Please ask for: Nicola Moore
Email: nicola.moore@arun.gov.uk
Telephone: Ext 37944
Our Ref: LU/26/21/CLP
Your Ref:
Date: 27th January 2021

Lawful Development Certificate for a Proposed Use or Development

Development: To place 9 Trina 325W all black mono (small 1690 x 996) solar panels in one string on the roof to the rear of the property as per roof layout plan.
Location: 7 Foxglove Way Littlehampton BN17 6UN

7 Foxglove way
Side elevation

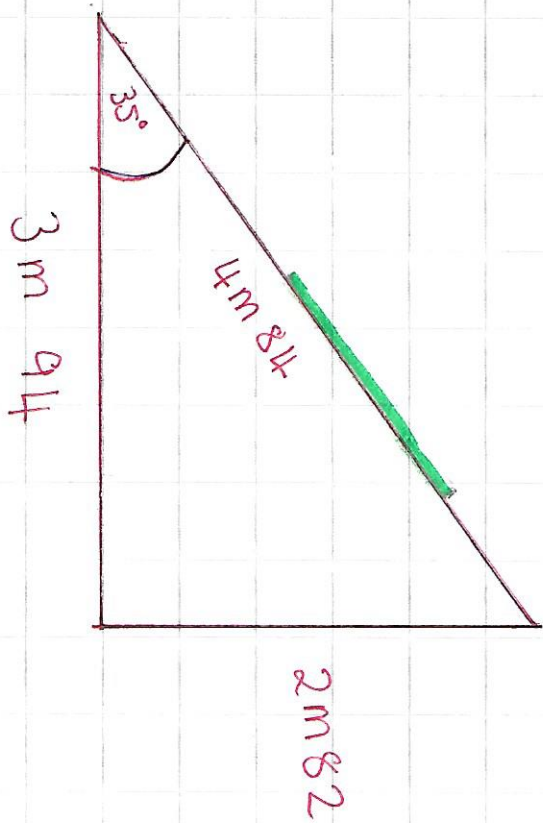
Elevations

Please submit Proposed Elevations showing the proposed solar panels. This could be photo or a drawing that includes all dimensions of the panels on the roof.
